Strategic Drainage Consultation

Consultation on Application Number: 2016/62/90494/W

Address: adj Old Bank Mill, Howgate Road, Slaithwaite, Huddersfield, HD7 5AR

Proposal: Erection of 24 flats in two blocks with associated external works, drainage works and new road

PROPOSED RESIDENTIAL DEVELOPMENT AT OLD BANK, SLAITHWAITE			
CLIENT S.B. HOMES LTD			
WILLIAM BEST RISA THE CHAPEL HOUSE 22, FOLE GATE SCAMMONDEN WEST YORKSHIRE HD3 3PW 01484 845896			
DRAWING: PROPOSED SITE PLAN			
SCALE:	B4	DATE	
1:200	WB	14/01/2016	
2015/319	100

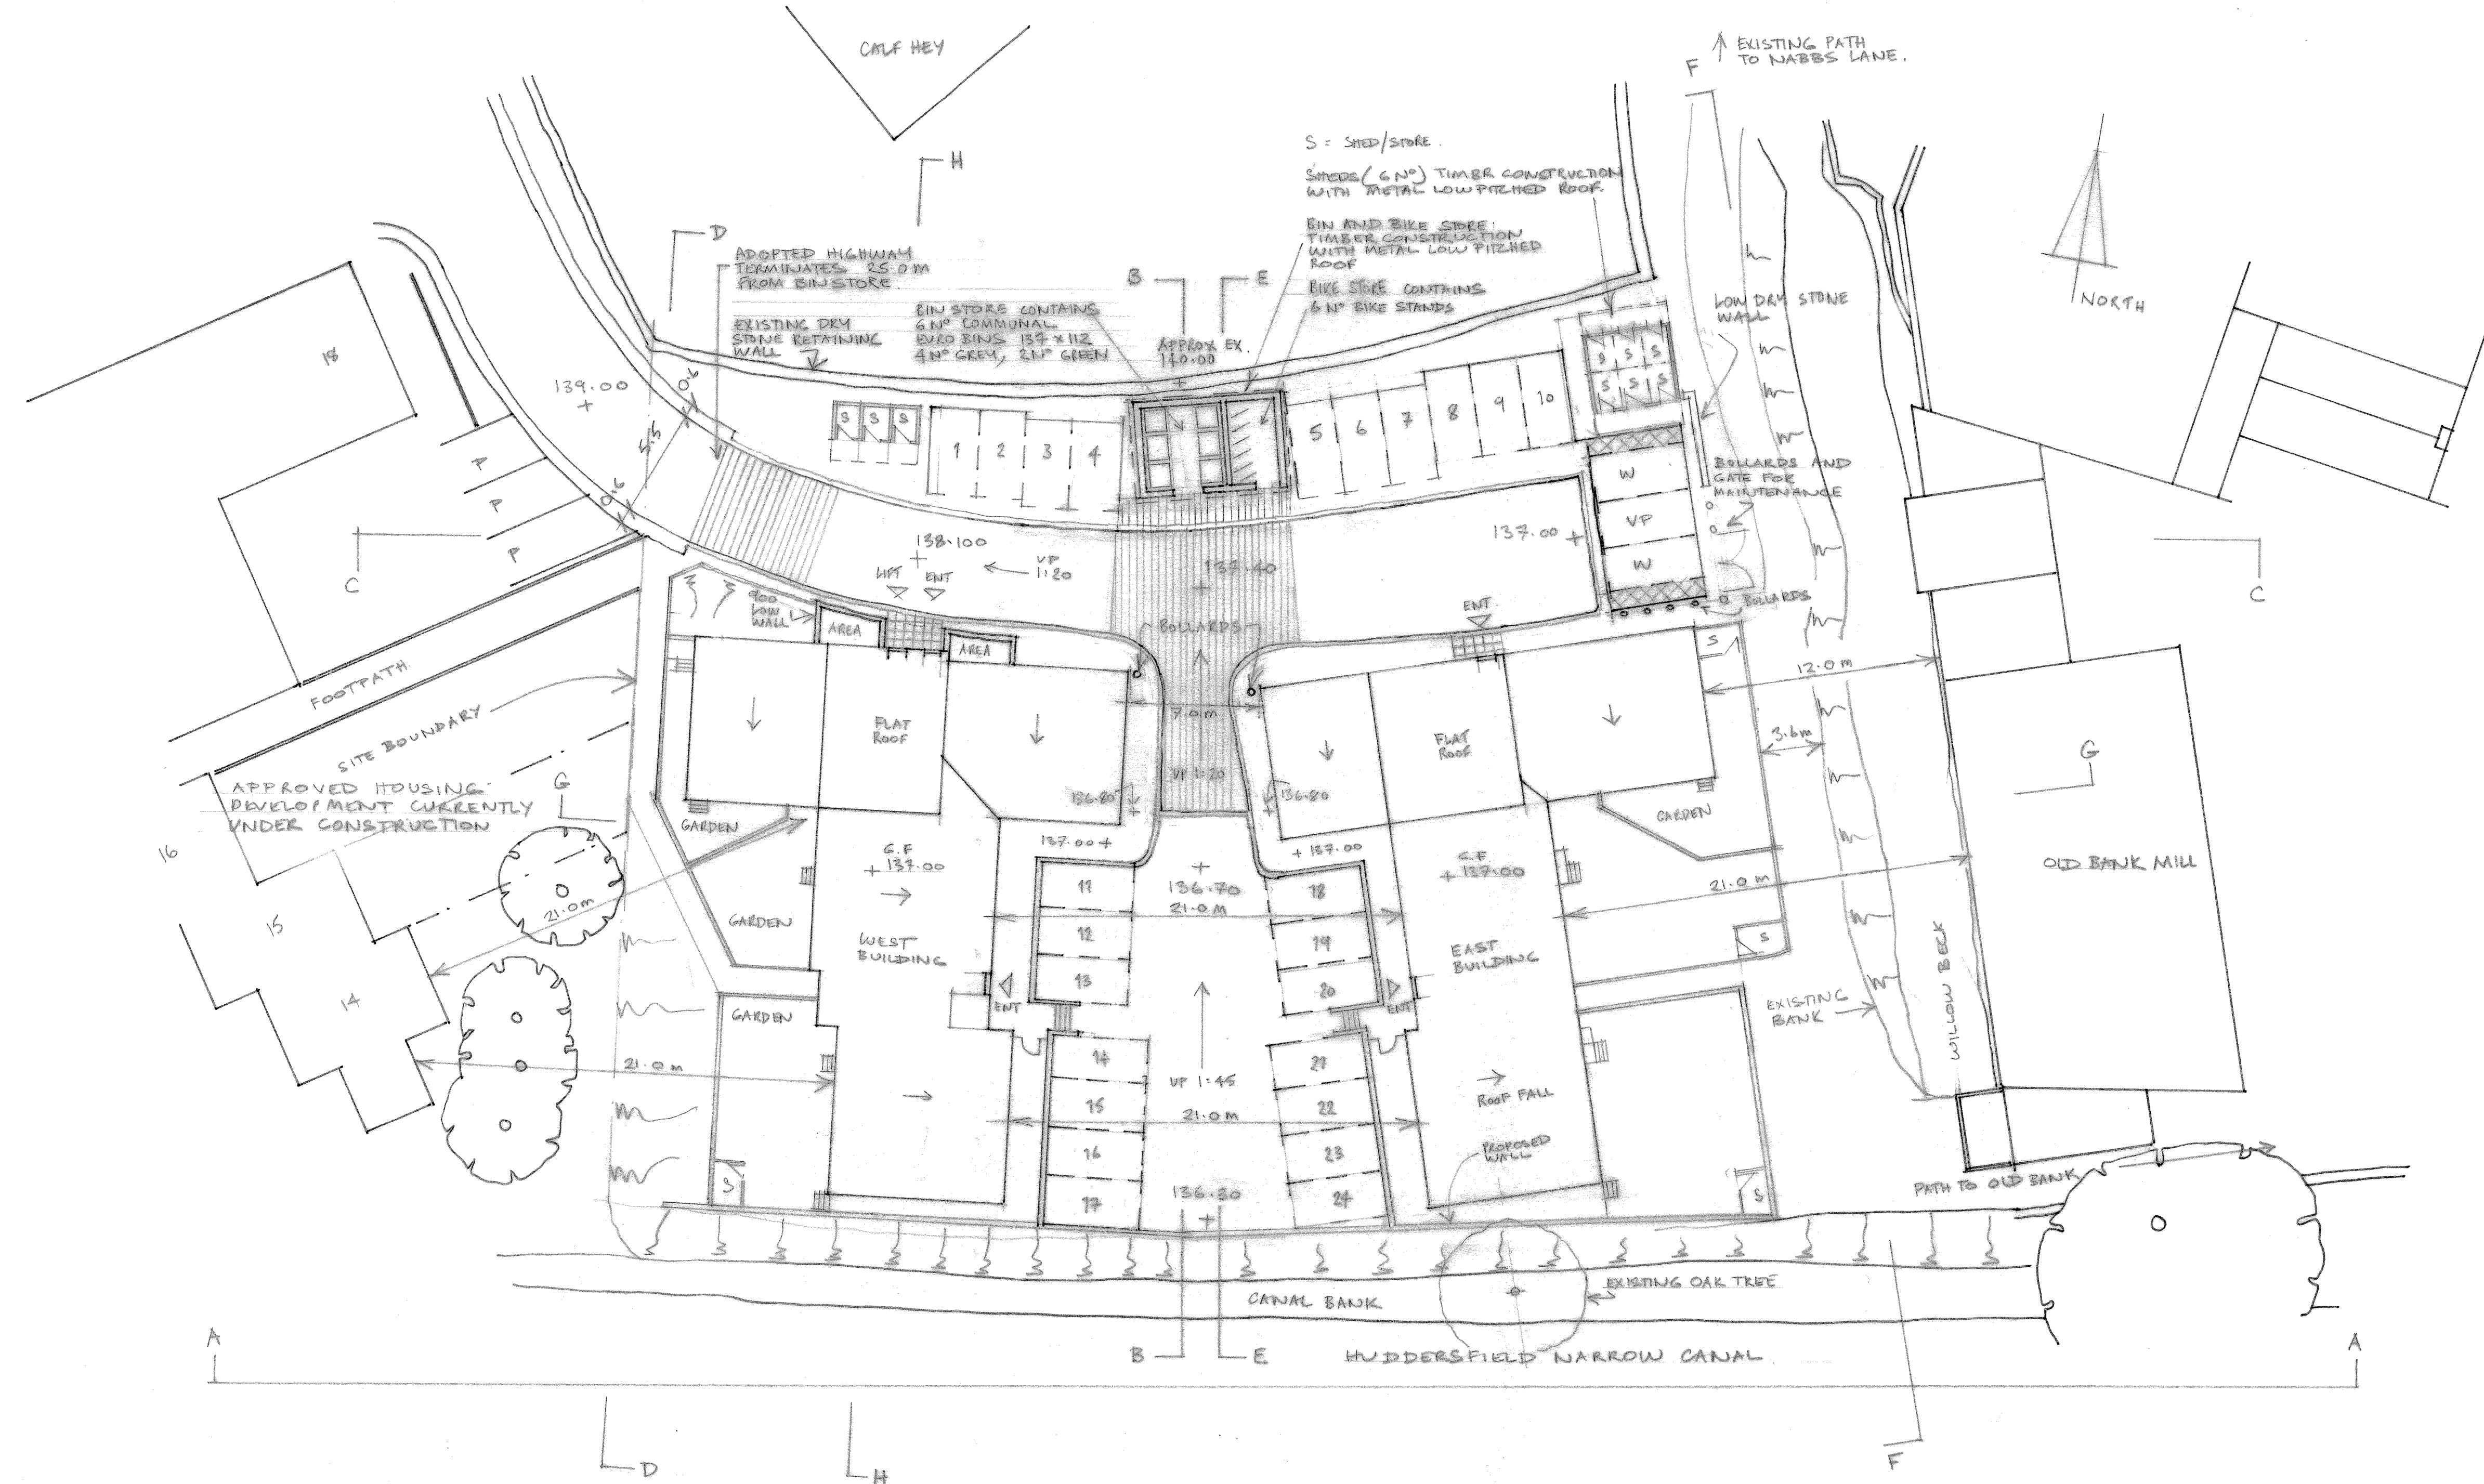
Further information is requested to be submitted prior to agreeing layout design for this application. It is essential that surface water flooding is addressed at this stage and above ground storage requirements and indicative flood routing.

- Survey of existing Highway gullies in Howgate to see if they will influence on site drainage design.
- Size and condition of the culvert running through the site (pick up in additional application for area outside red line).
- Discussion and agreement around invert levels of the outfall, alterations to the ordinary watercourse and surcharged outfall design. (essential for this application before conditions can be set)
- Cross sections around flooding parking areas in the 1 in 100 + climate change critical storms (discussion essential before conditions can be set)
- Indicative flood routing (for feasibility and to be taken forward by condition)
- Dealing with the catchment surface water flooding shown on risk maps (not addressed in the assessment).

Drainage design under proposed adoptable highway should also seek early consultation with our section 38 and structures team for submission for adoption requirements.
